**NEWARK &
SHERWOOD**
DISTRICT COUNCIL

WRITTEN REPRESENTATIONS

A46 NEWARK BYPASS

SUBMISSION AS THE LOCAL PLANNING AUTHORITY

ORIGINAL SIZE	A3	SCALE	1:20,000	PROJECT REF NO.	HE551478
DRAWING NUMBER	HE551478	ORIGINATOR	SKAG	VOLUME	EGN
LOCATION	CONWI_CONW	DR	LE	00008	REVISION
		TYPE	ROLE	NUMBER	C01

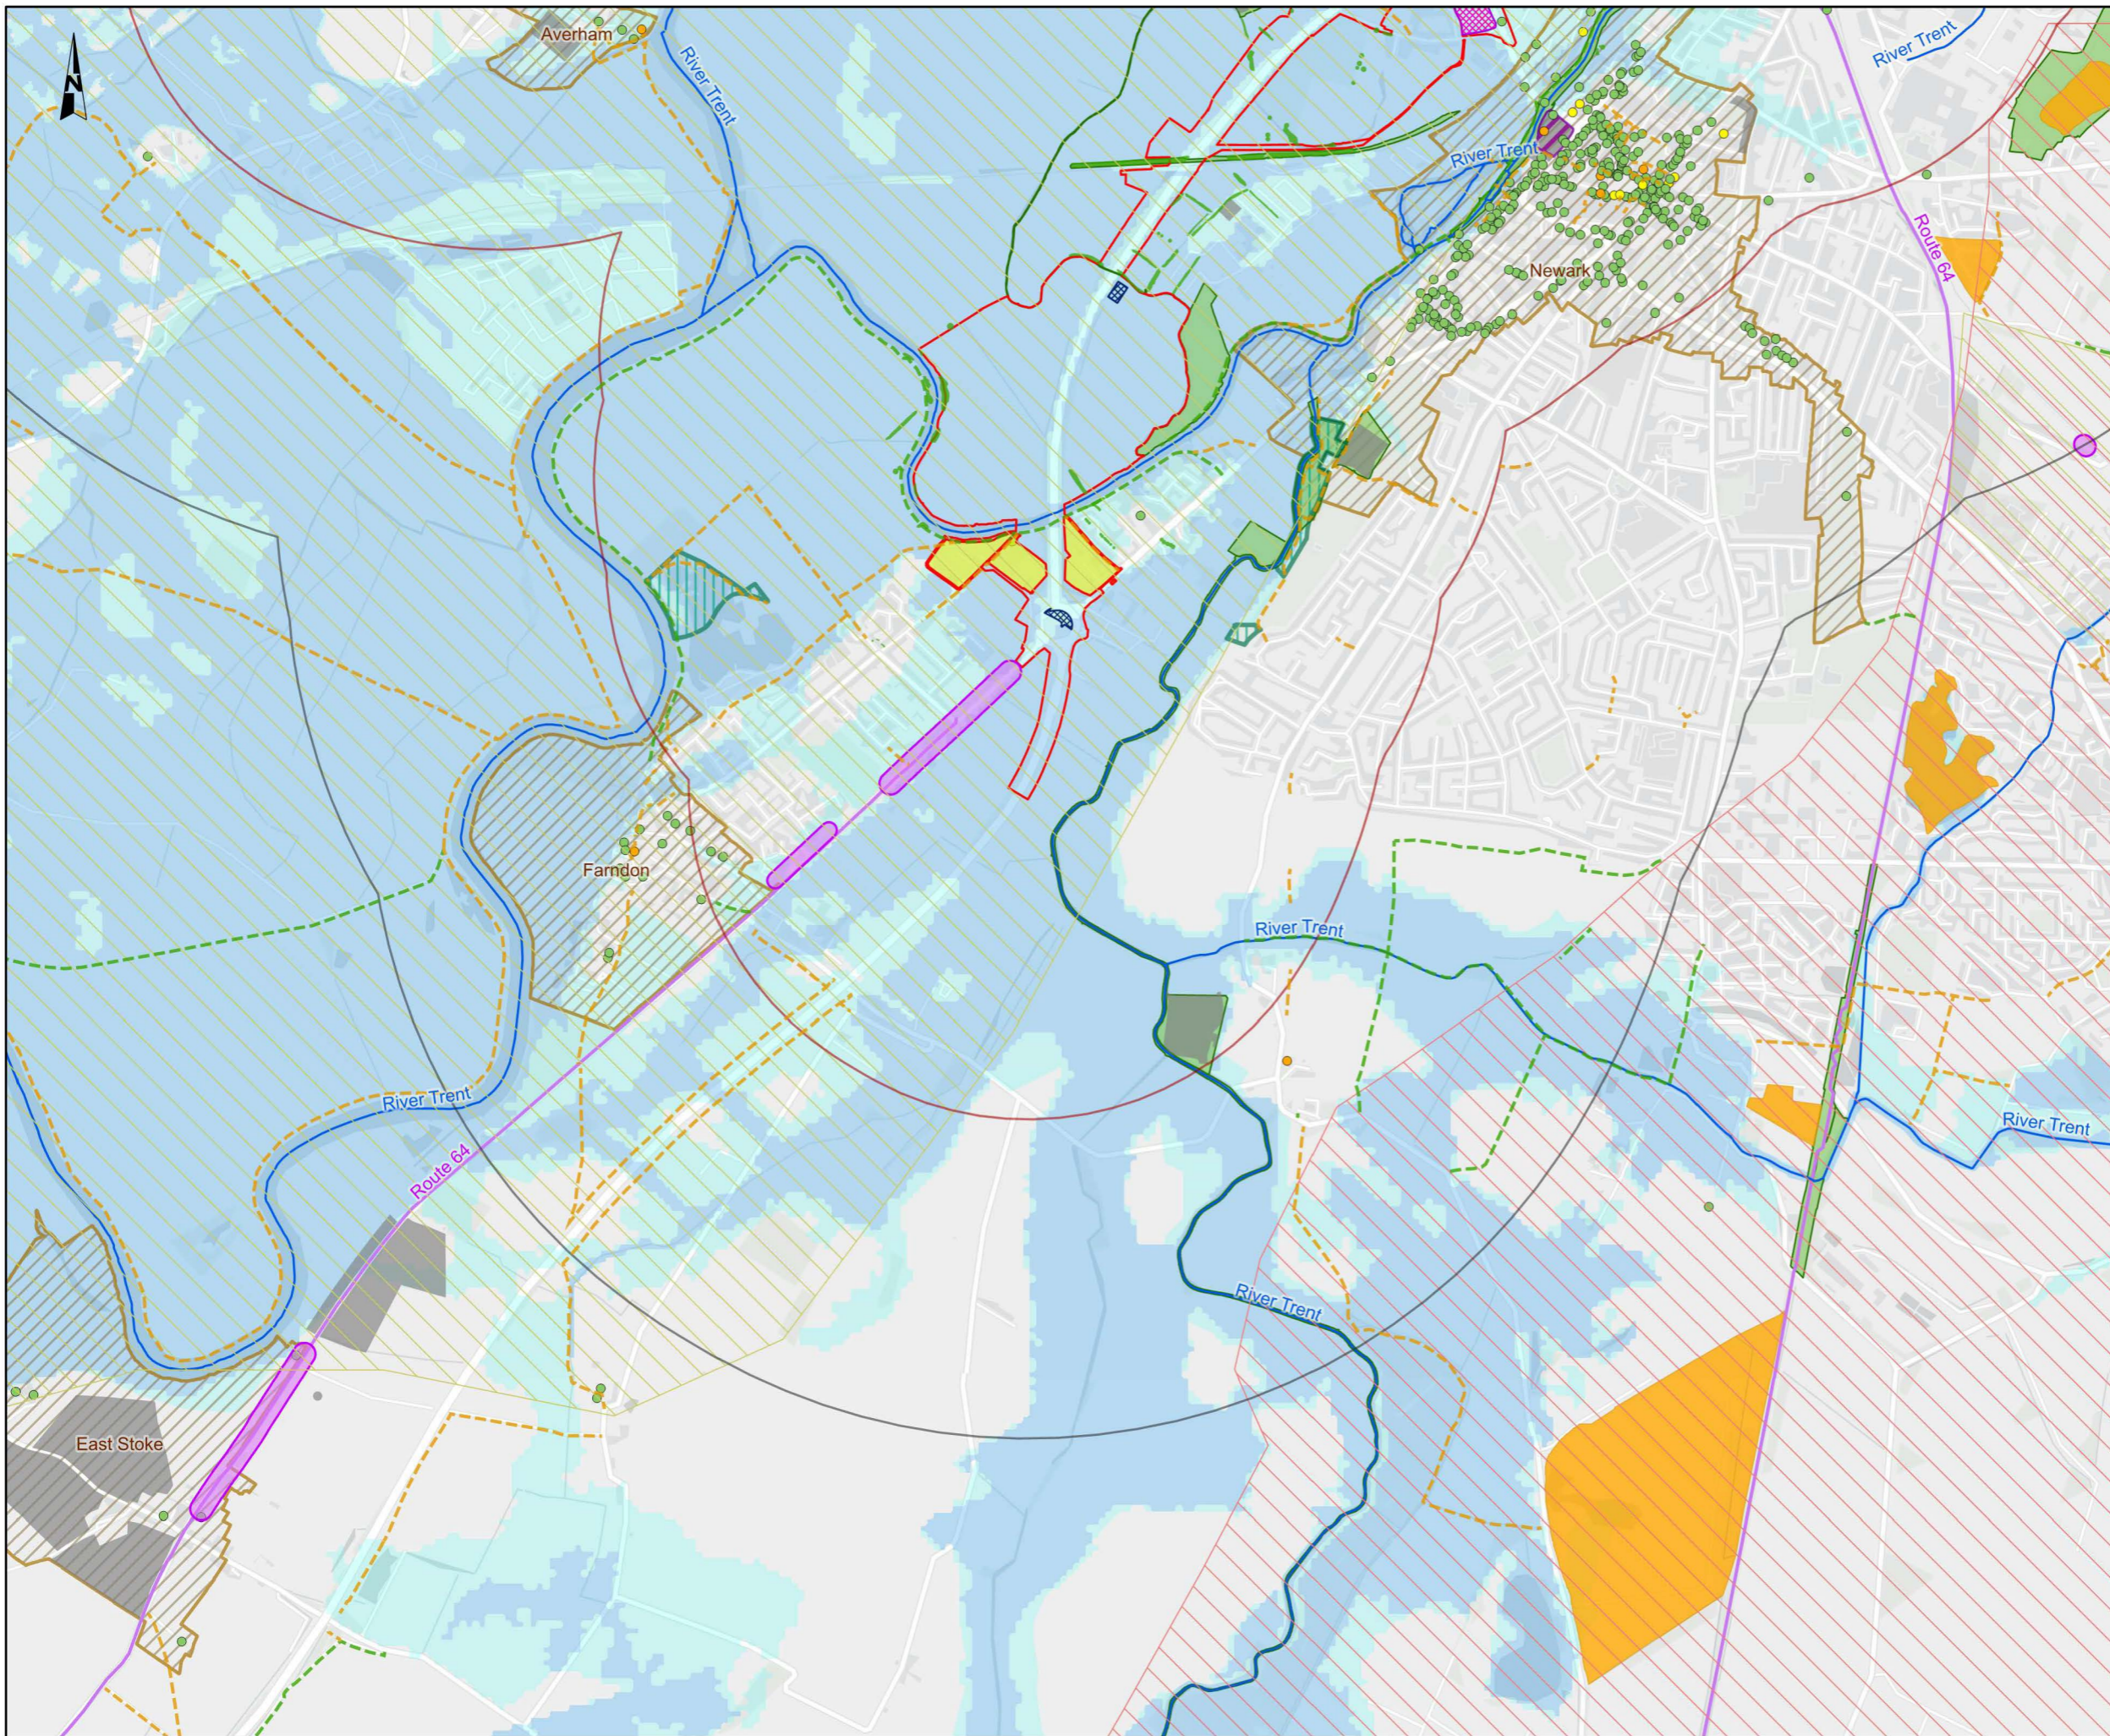
- The applicant has not identified all key designations that contribute to Landscape Character or visual matters which include nature conservation sites. These designations haven't been listed in Table 7.6. though they have been identified on the Constraints Plan Figure 2.2 Environmental Constraints Plan. These should be included within Chapter 7 Landscape and Visual Effects assessment;
